WEST SUSSEX COUNTY COUNCIL CONSULTATION

TO:	Arun District Council FAO: Mr S Davis
FROM:	WSCC - Highways Authority
DATE:	05 September 2019
LOCATION:	9-11 Abbeyfield Richmond Avenue Bognor Regis PO21 2YE
SUBJECT:	BR/145/19/PL Conversion of existing vacant residential care home into 8no. flats. More information received.
DATE OF SITE VISIT:	n/a
RECOMMENDATION:	No Objection
S106 CONTRIBUTION TOTAL:	n/a

PROPOSED NORTH ELEVATION

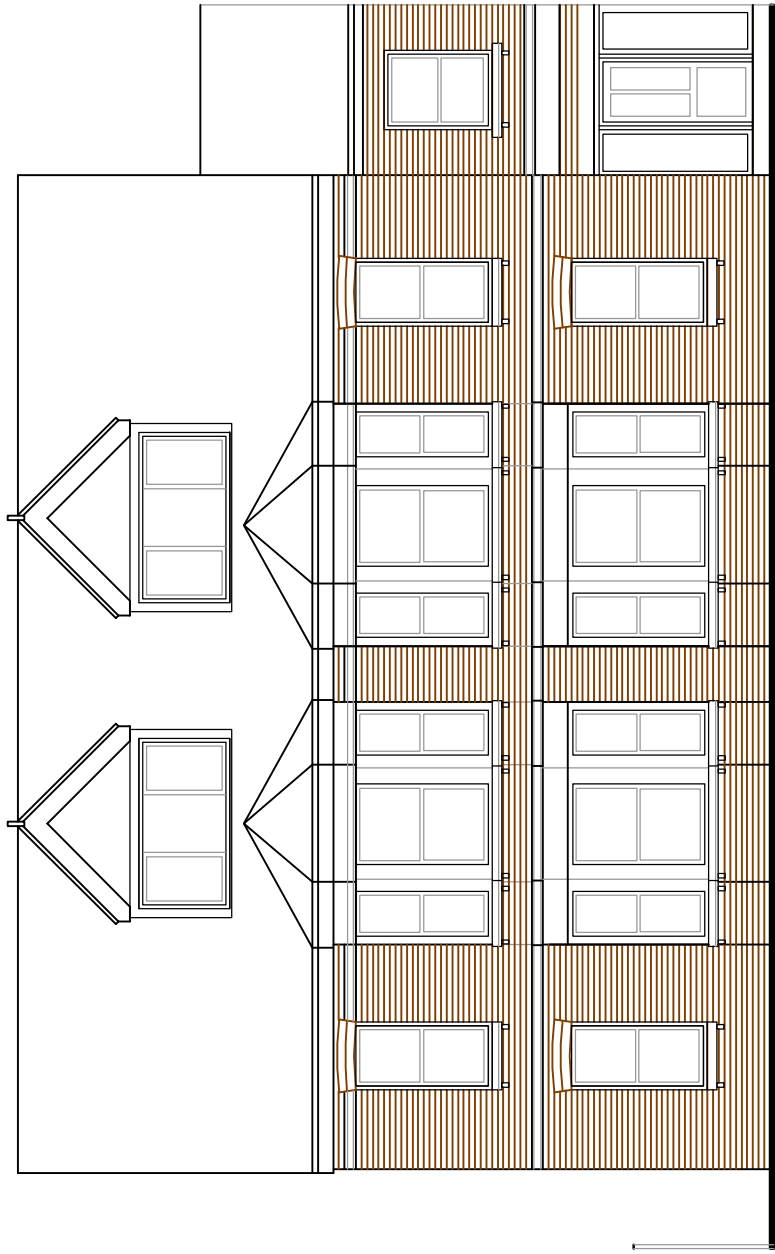
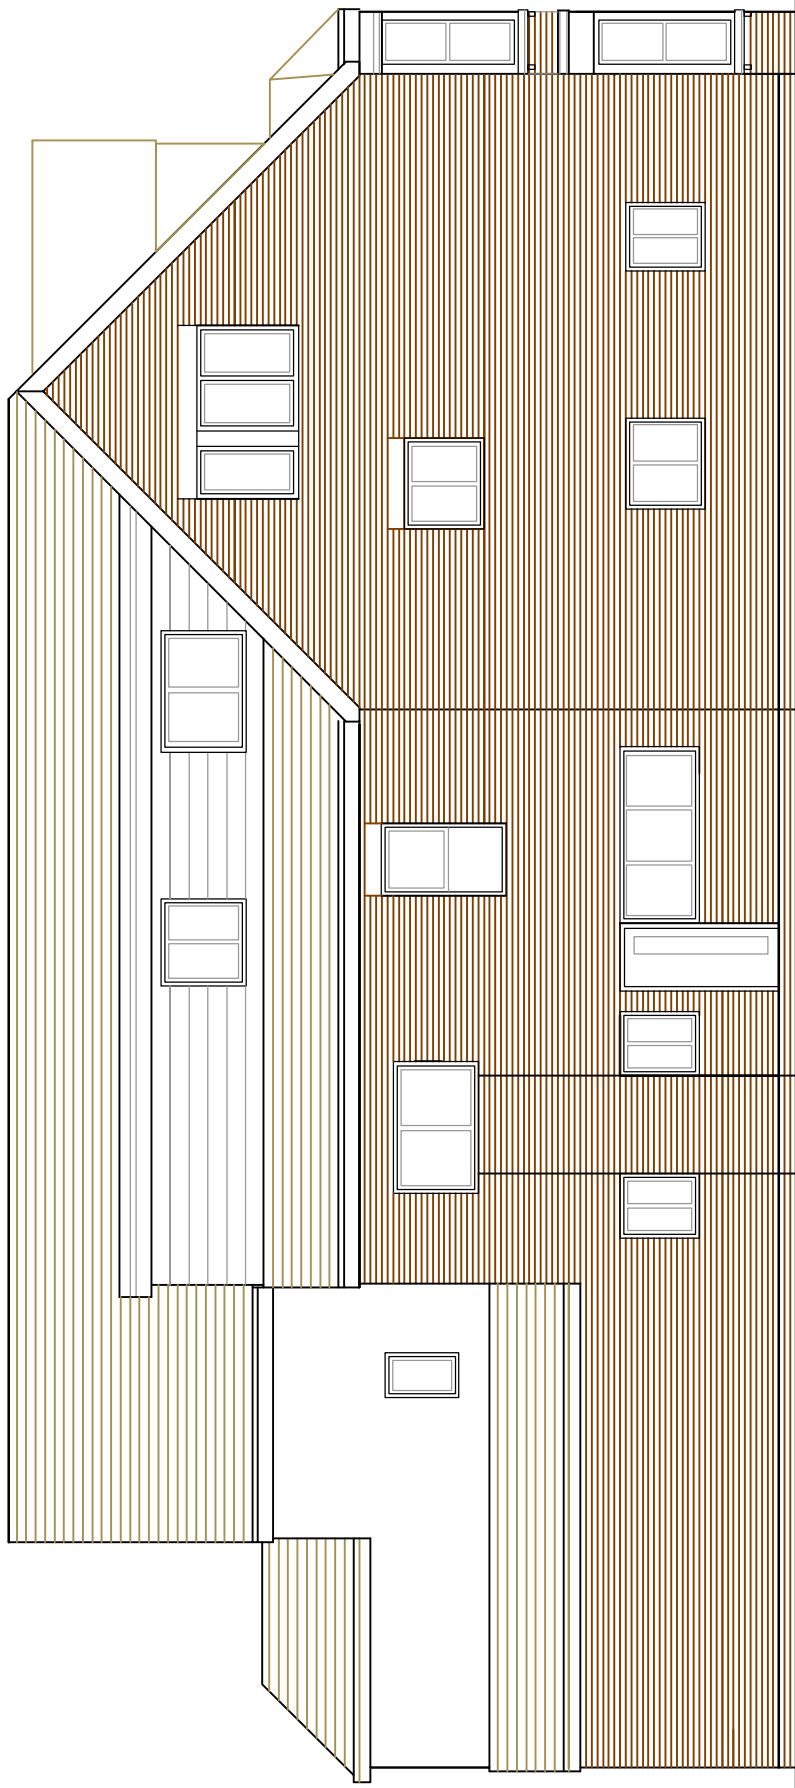
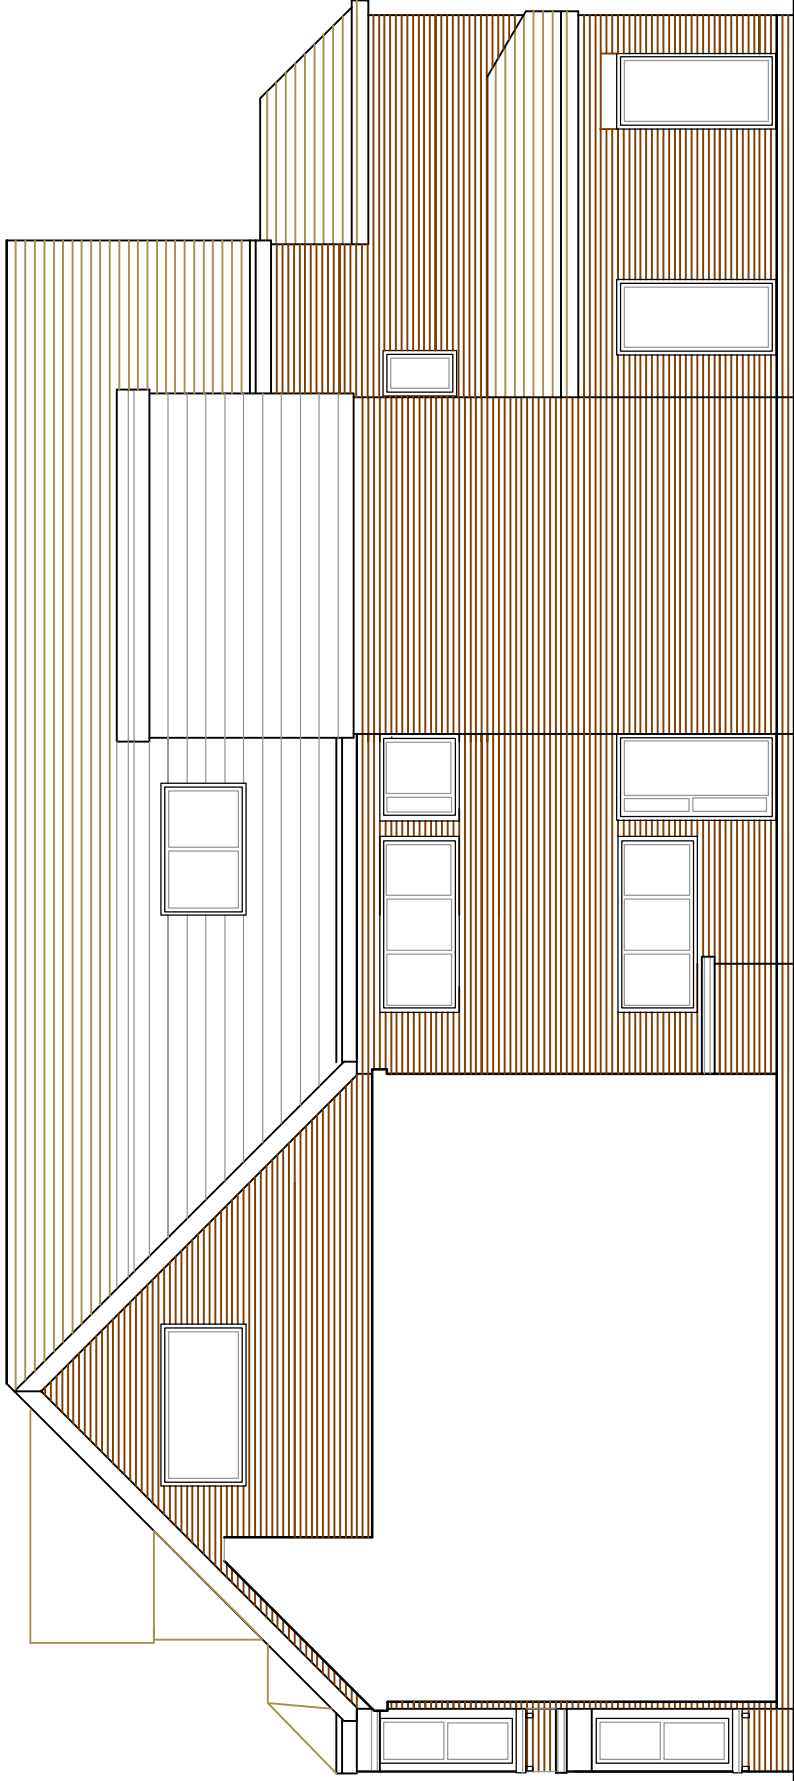
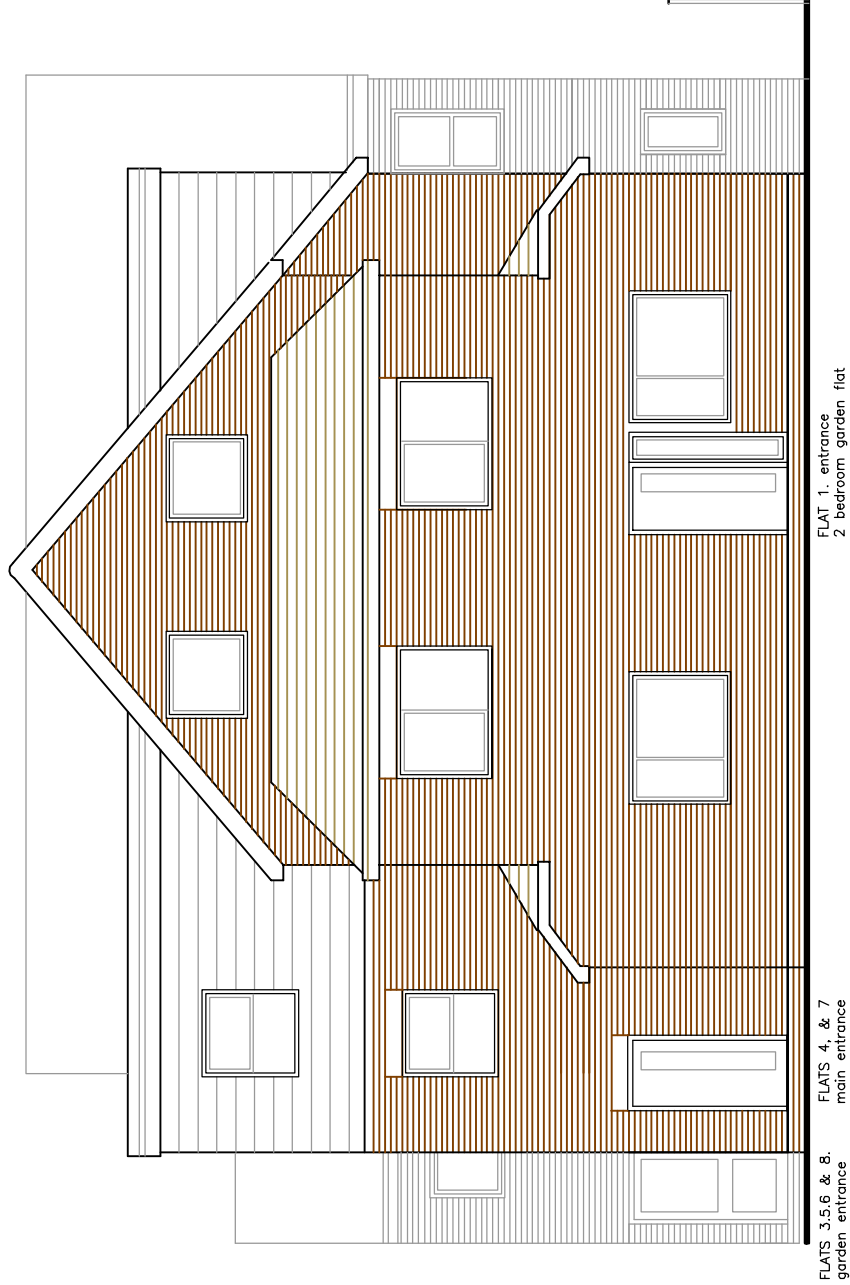
It has been stated that the grey box currently fixed to the northern elevation of the property will be removed to facilitate one of these parking spaces. Currently there would be insufficient space to accommodate an average sized vehicle without overhanging onto the footway and causing an obstruction to pedestrians.

PROPOSED GROUND FLOOR

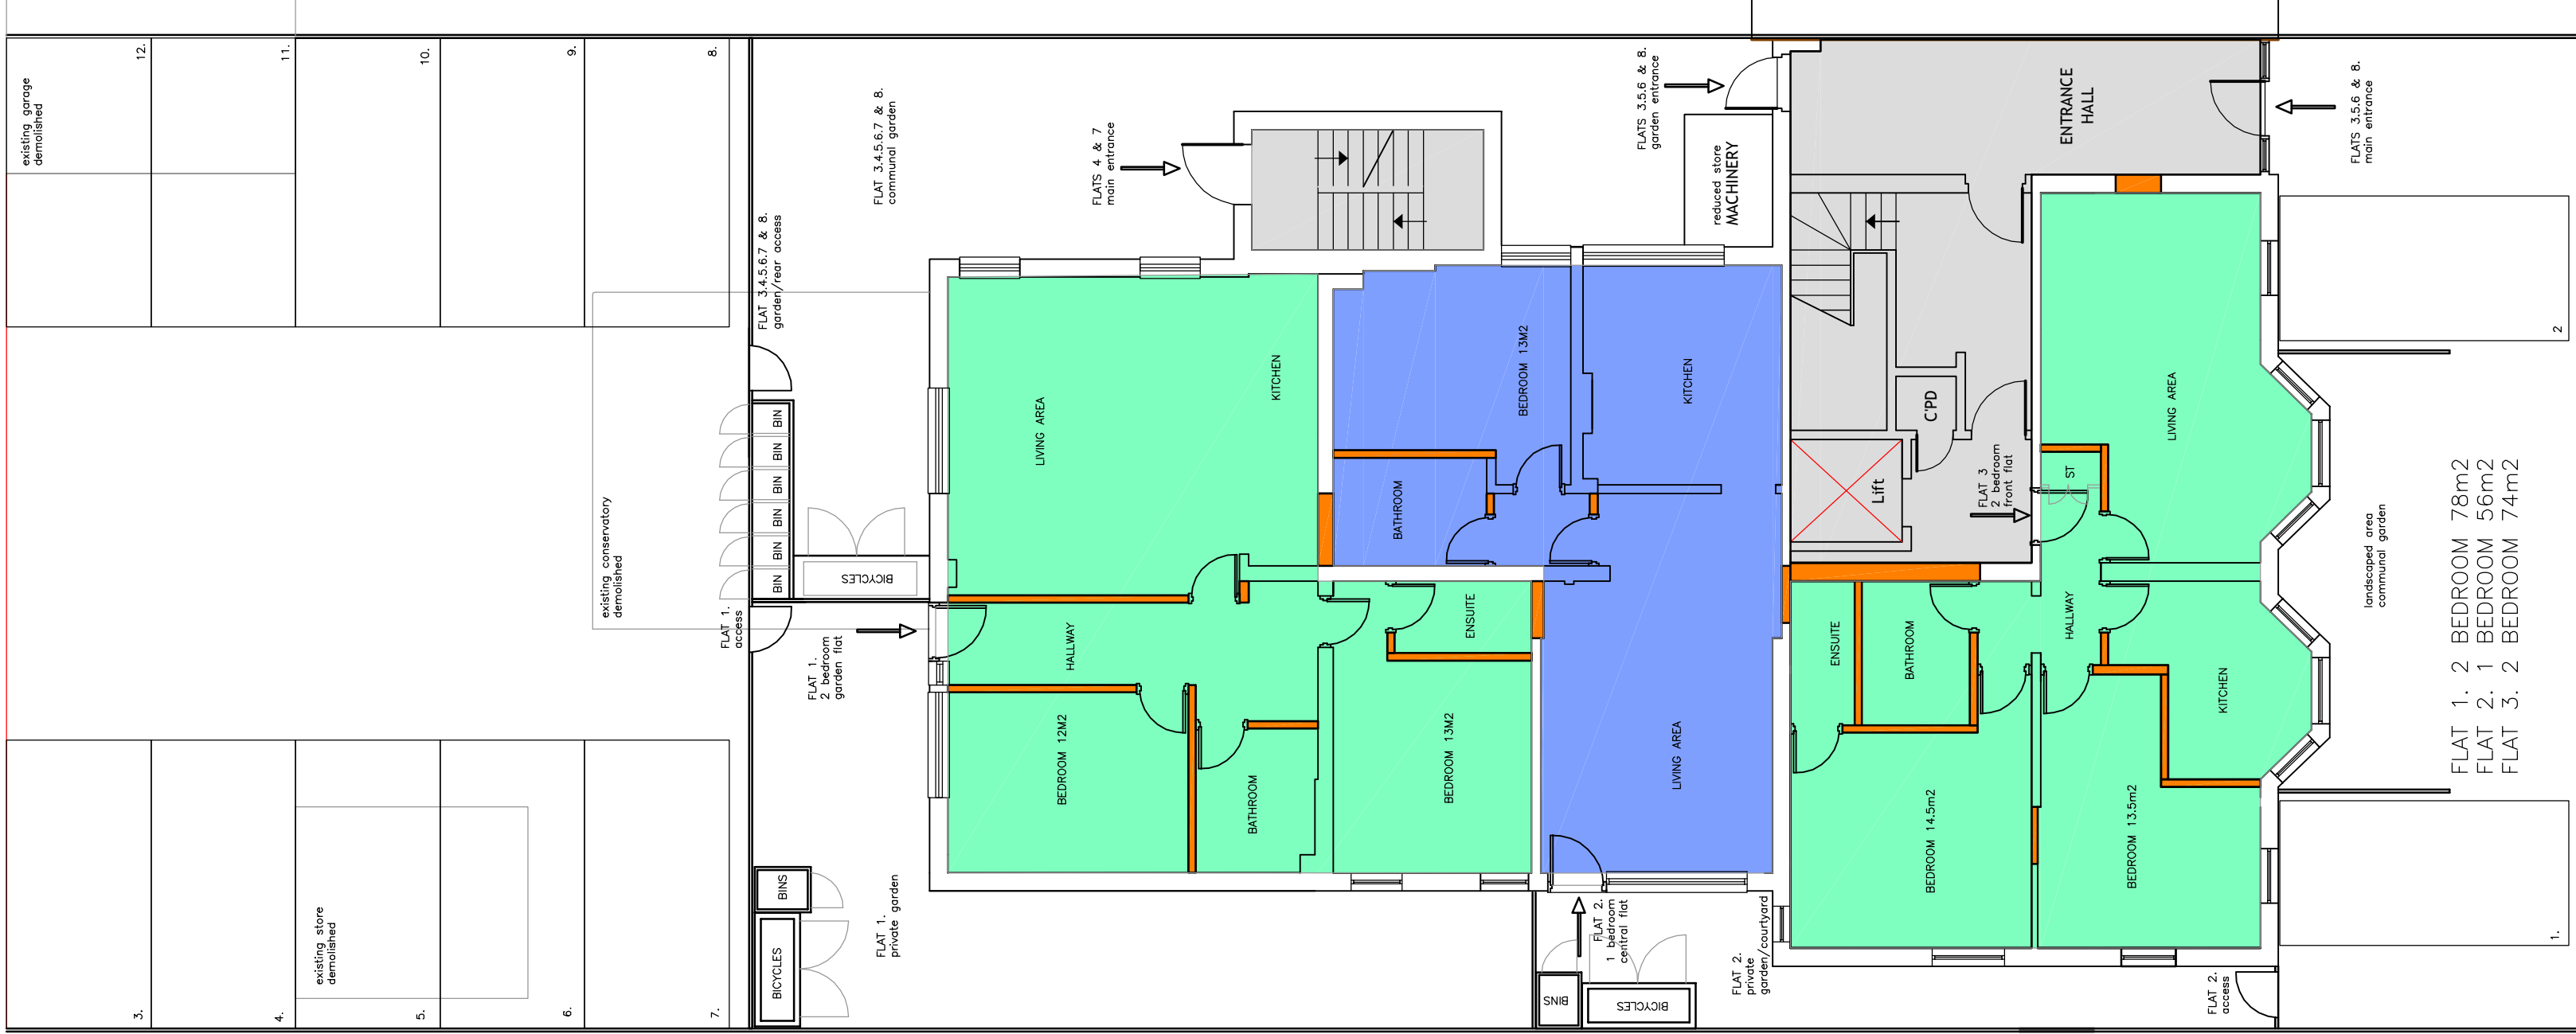
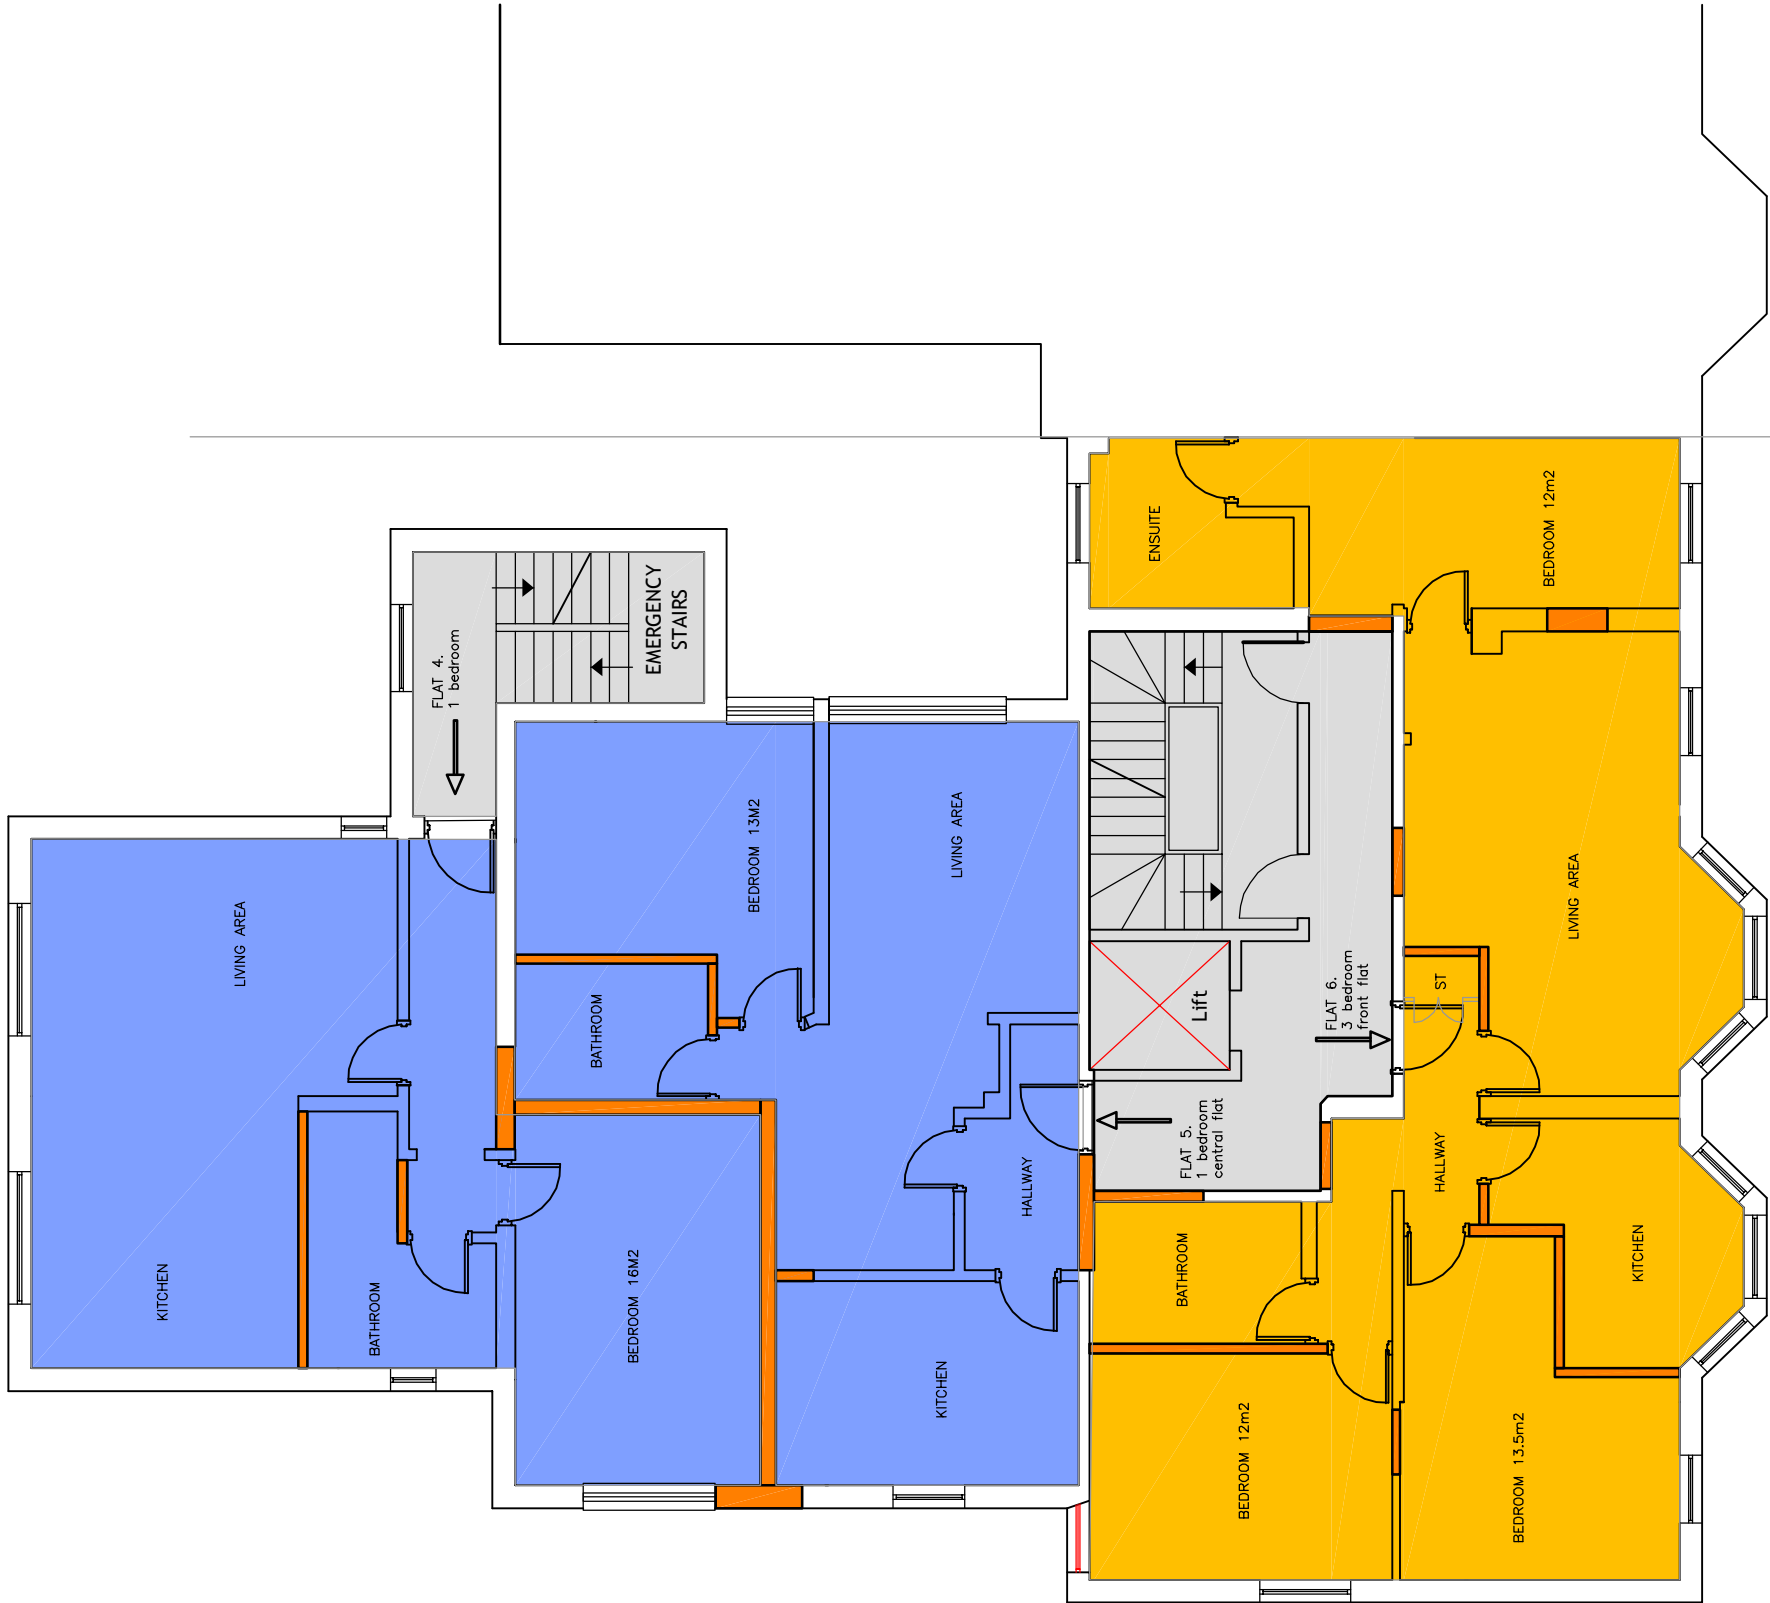
The newly submitted parking layout is an improvement over that previously submitted. the spaces are of sufficient dimensions to accommodate an average sized vehicle and 6m has been accommodated to the rear of these spaces to facilitate a turn on site.

The two vehicular parking spaces proposed to the front of the property will require two separate vehicular crossovers to be constructed, leading onto Richmond Avenue. The applicant will be required to contact the Area Officer for Arun to apply for a license to carry out these works on the publicly maintained highway.

No part of the development shall be first occupied until such time as the vehicular access serving the development has been constructed in accordance with the details shown on the drawing titled Proposed Plans and numbered 288/03 revision A.
